DEVIATION REVIEW AND DECISION FORM

Subdivision or Project Name: WindingWalk Filing No 1 at Meridian Ranch.

Section of ECM from which Deviation Is Sought: 2.3.3.F.3

Specific Criteria from which a Deviation Is Sought: Minimum tangent length between broken back curves on an Urban Local street.

PORCH SWING LN.

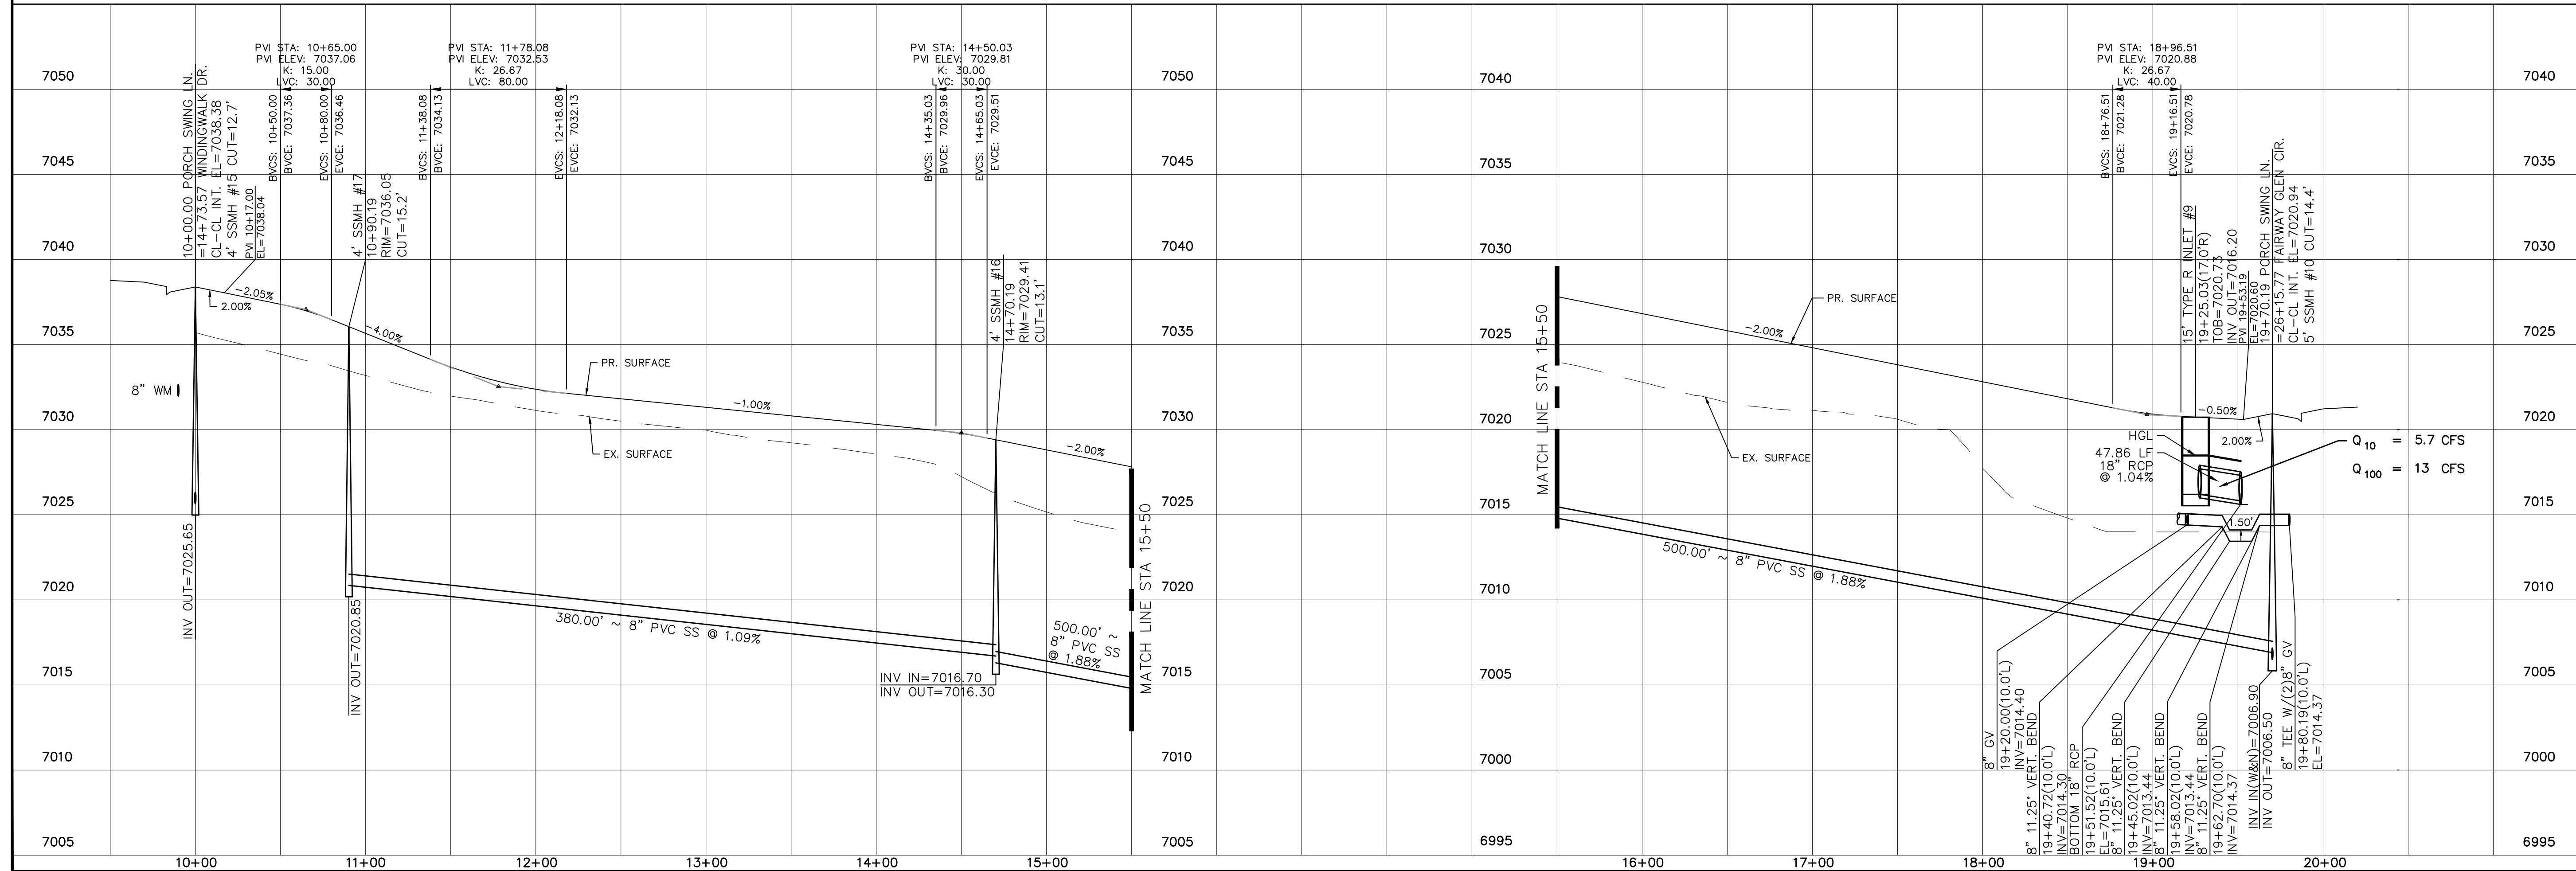
Proposed Nature and Extent of Deviation: The request for a deviation is to allow the proposed 163-foot-long centerline tangent length between the broken back curves on Porch Swing Ln – a Local street - at a location north of Stapleton Drive as shown on the plan and profile drawings.

Proposed Nature and Extent of Deviation: The request for a deviation is to allow the proposed 163-foot-long centerline tangent length between the broken back curves on Porch Swing Ln – a Local street - at a location north of Stapleton Drive as shown on the plan and profile drawings.

Comparison of Proposed Deviation to ECM Standard: The requested tangent length is 163 feet, which is 37 feet less than the ECM standard of 200 feet.

This request has been determined to have met the criteria for approval. A deviation from Section 2.3.3 of ECM is hereby granted based on the justification provided. Comments:
